Our ref: Marsden Park Data Centre (SSD-70889211)

Subject: Additional Matters for Submissions Report (SSD-70889211)

The Department's comments on the Environmental Impact Statement (EIS)

2 FRONT ELEVATION (FOH) - Type B  
1: 250

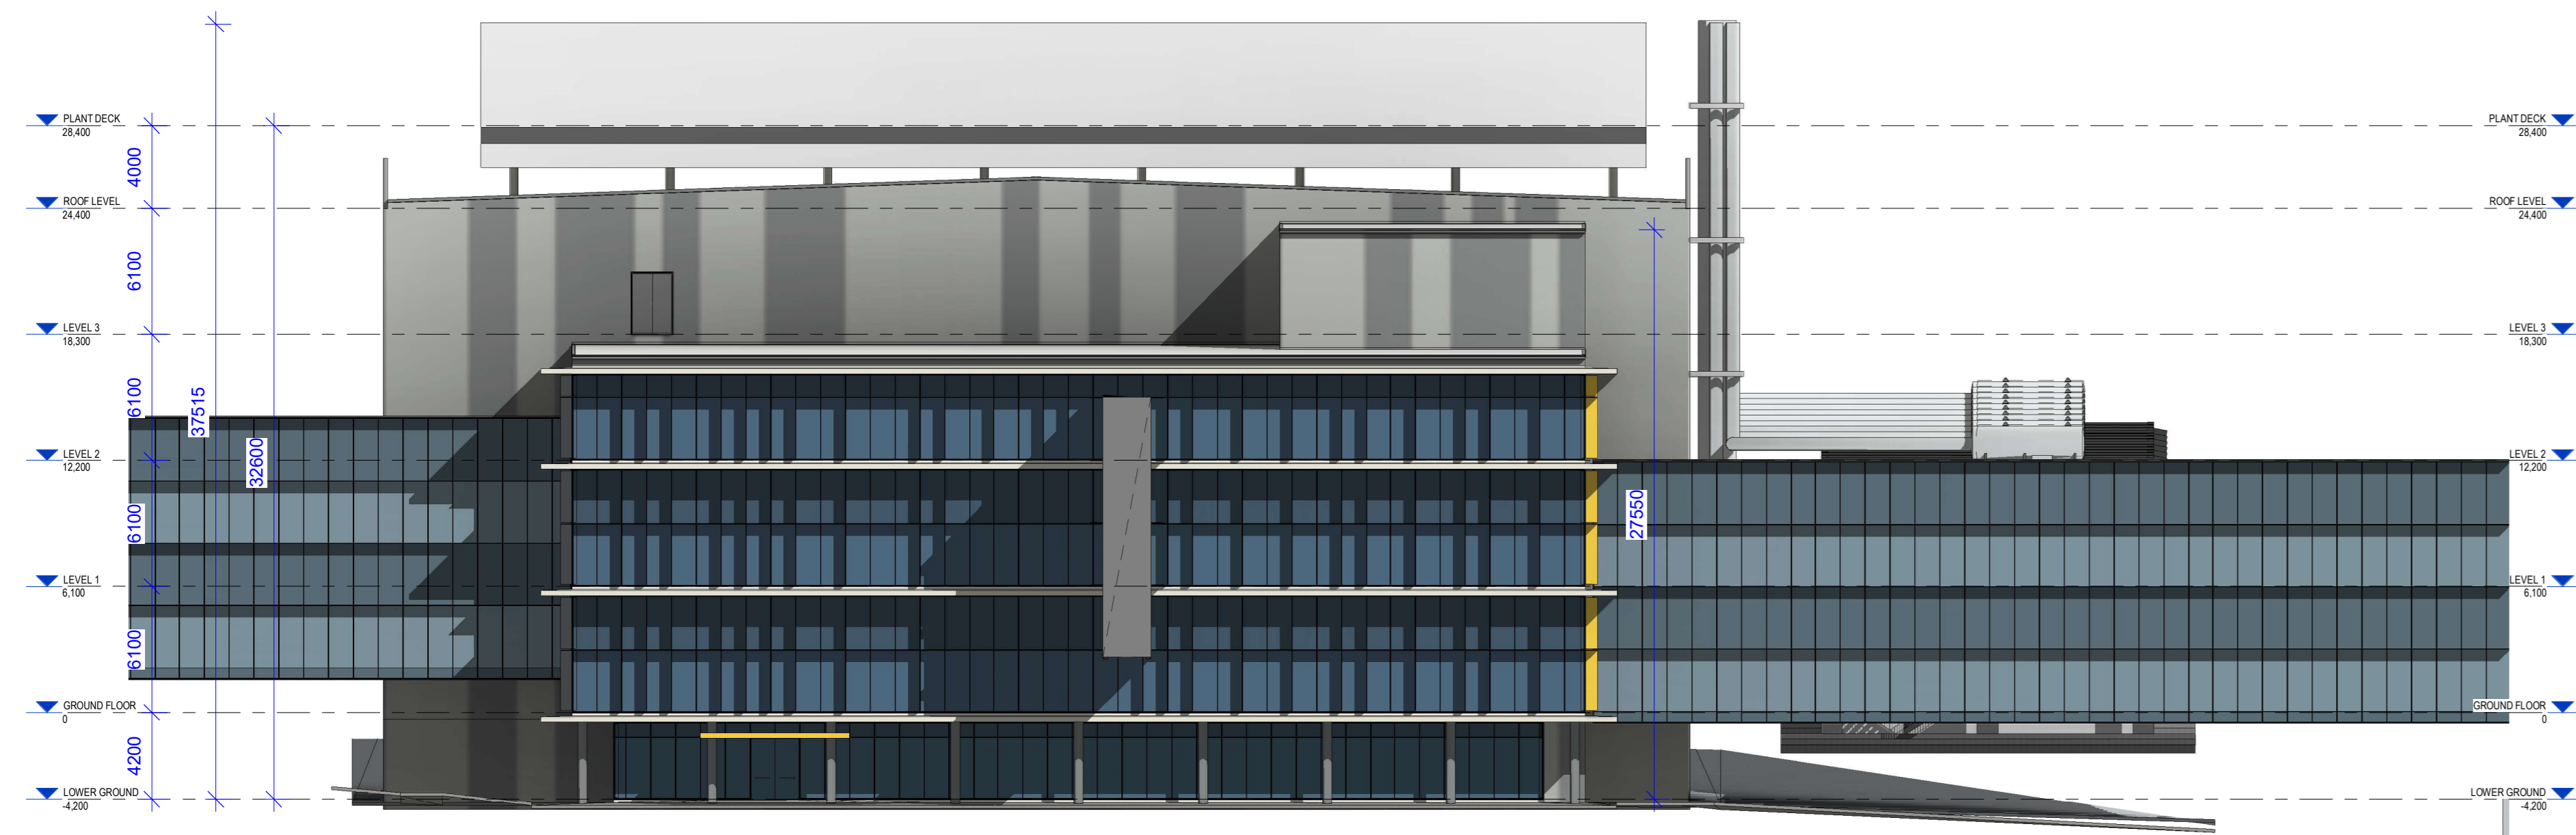
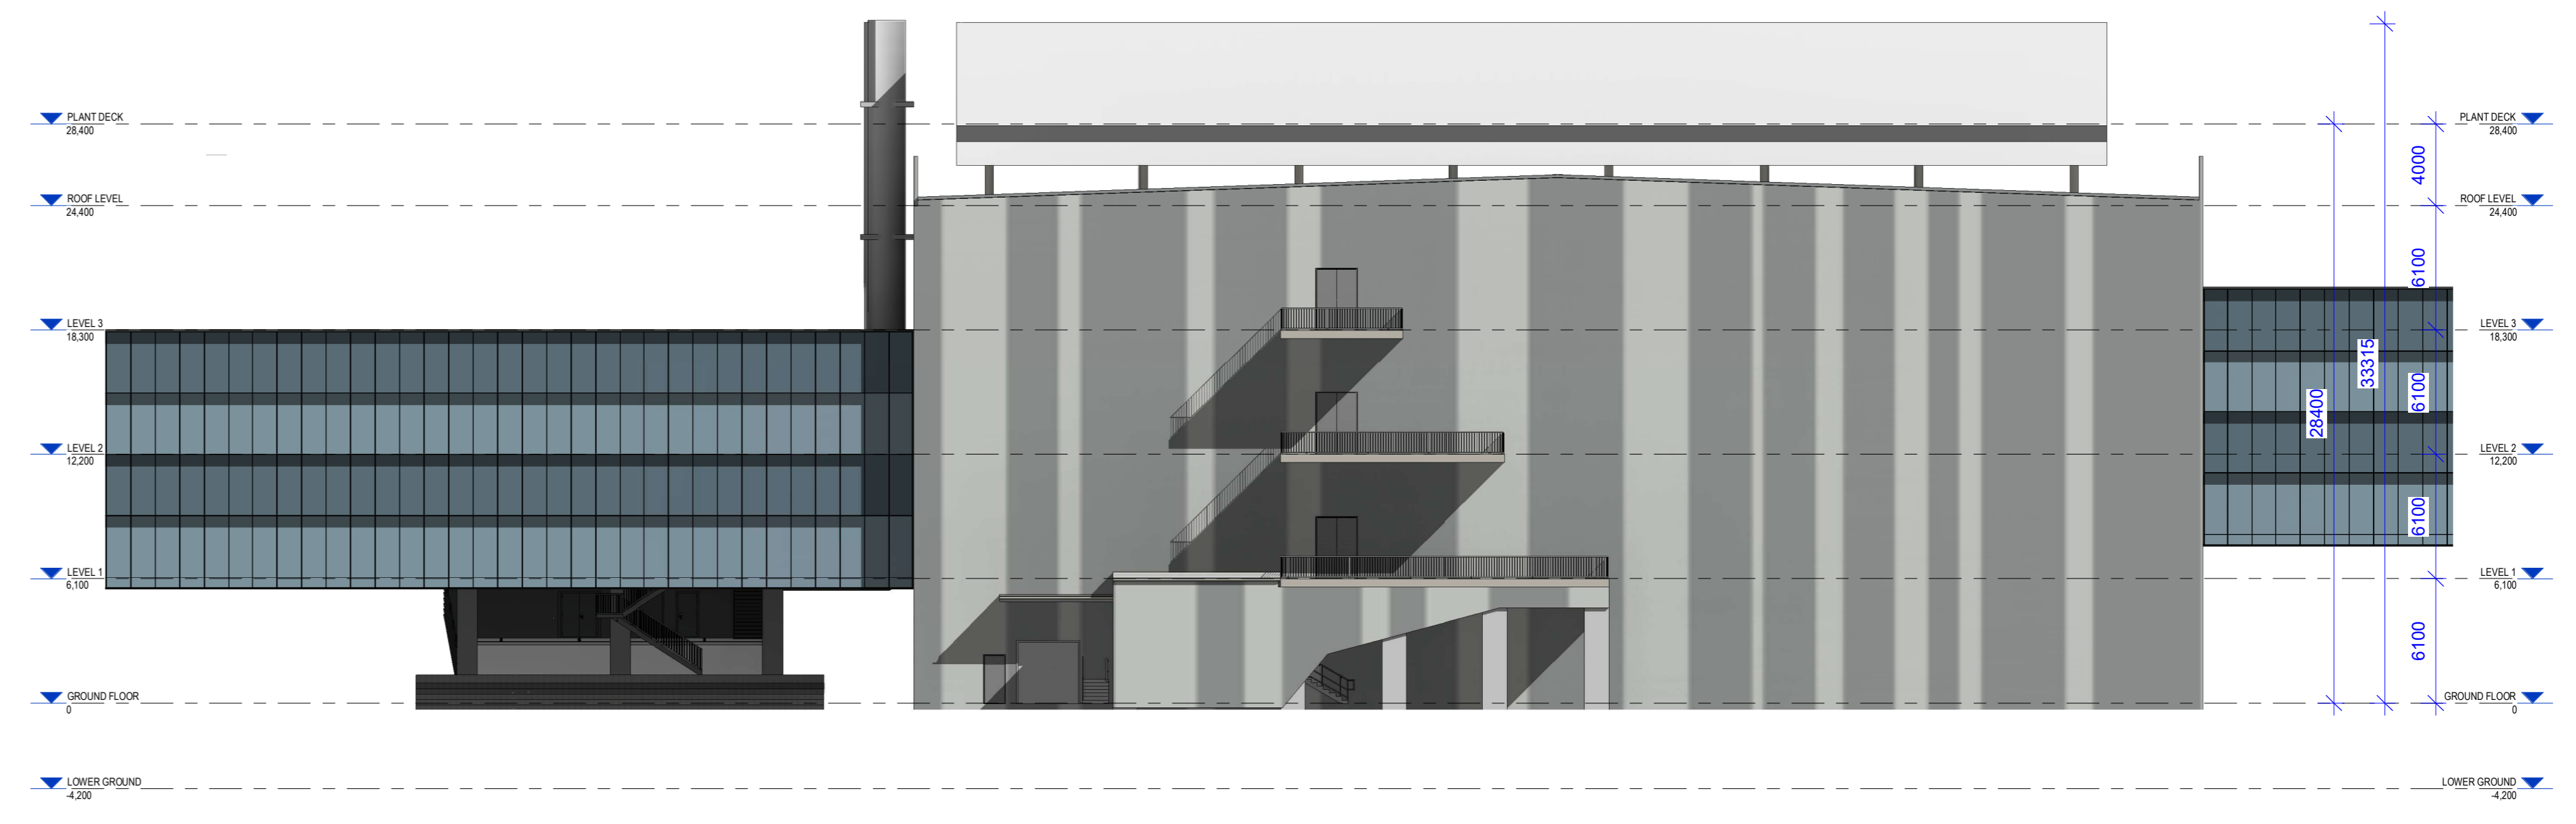
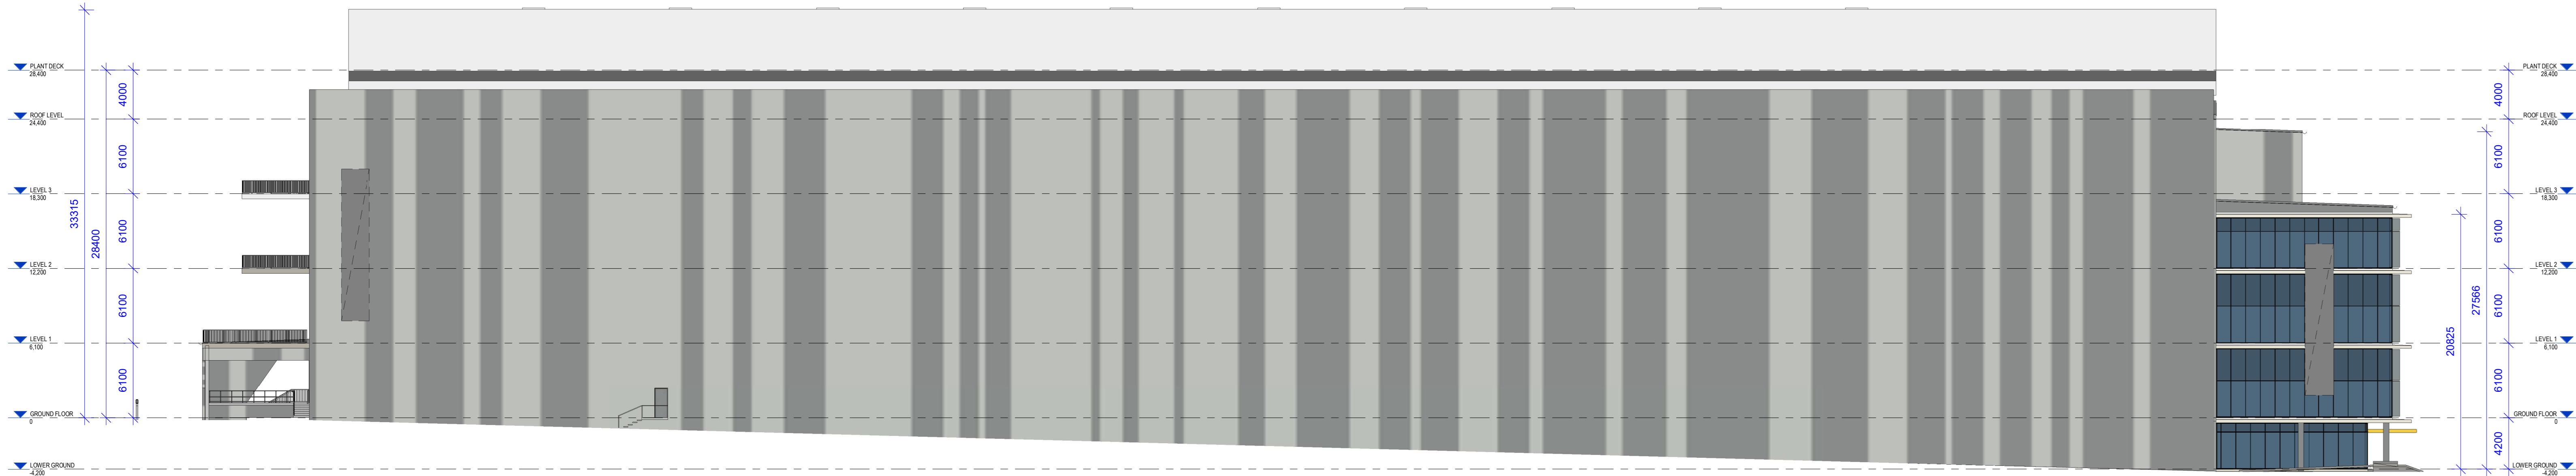
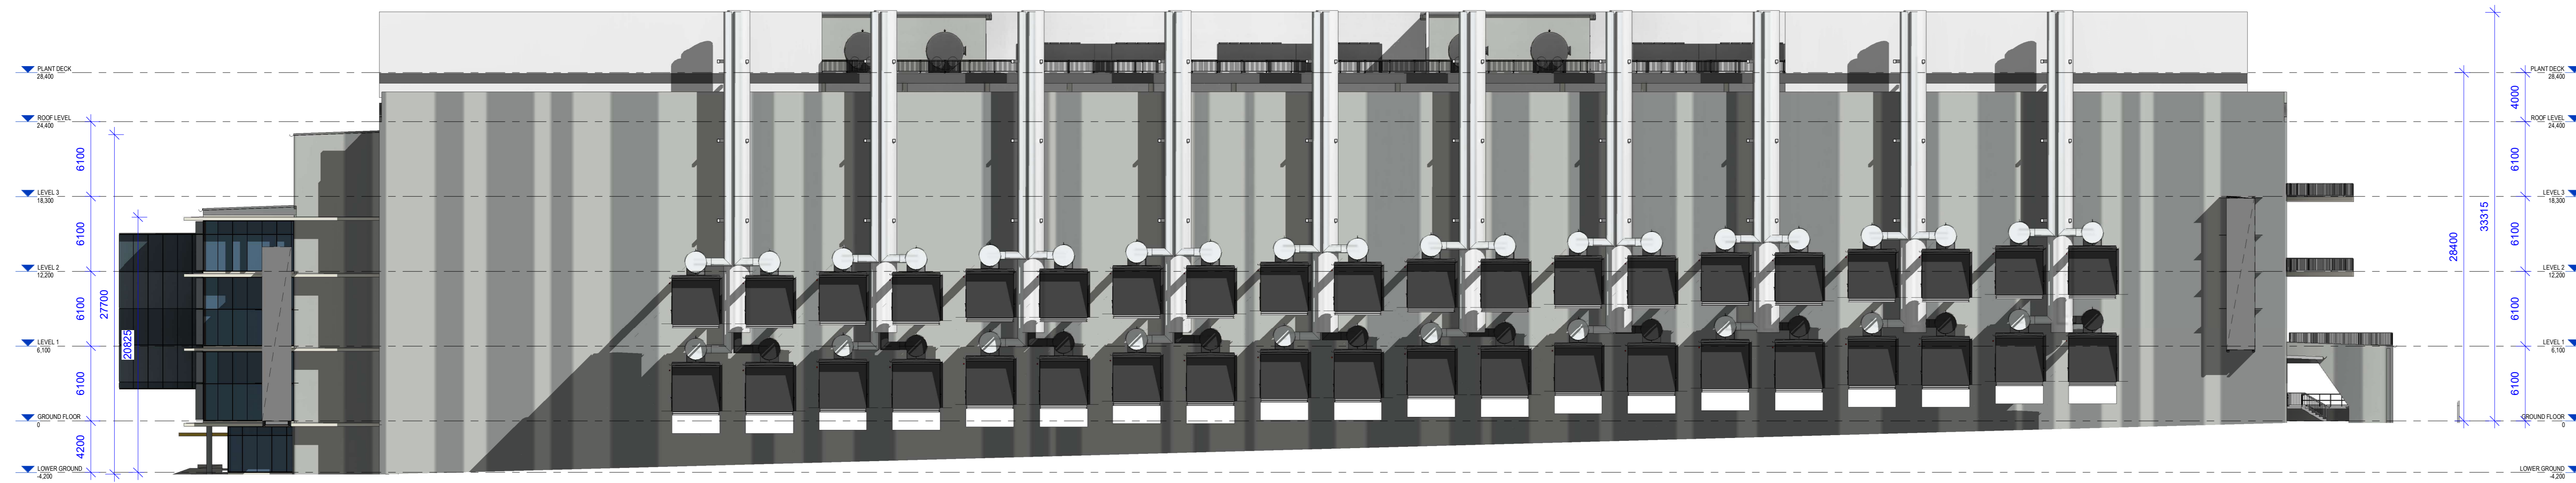
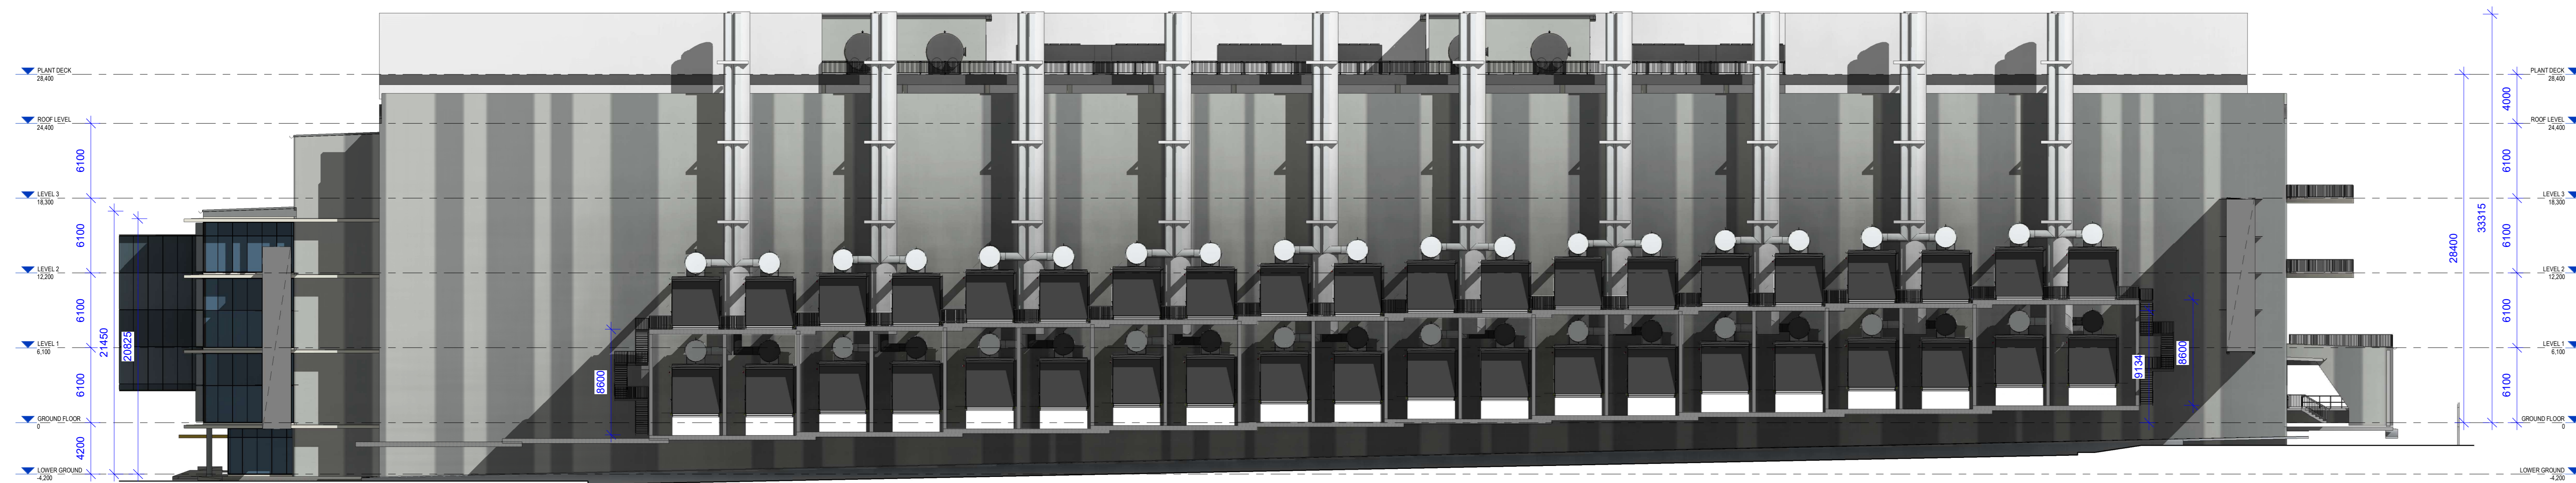
28. Given the proposed acoustic barrier treatments differ across each building, please provide detailed architectural plans for each of the six data centre buildings proposed under the subject SSD application.
29. The Department has concerns regarding the design of the development’s southern and eastern façades, particularly when viewed from residences to the south of the site.

In this regard, consideration should be given to improving the design of the development's southern and eastern facades so as to demonstrate design excellence and further soften the appearance of each data centre building. Such improvements could include, but are not limited to, the use of additional articulation and/or an alternative colour palette.
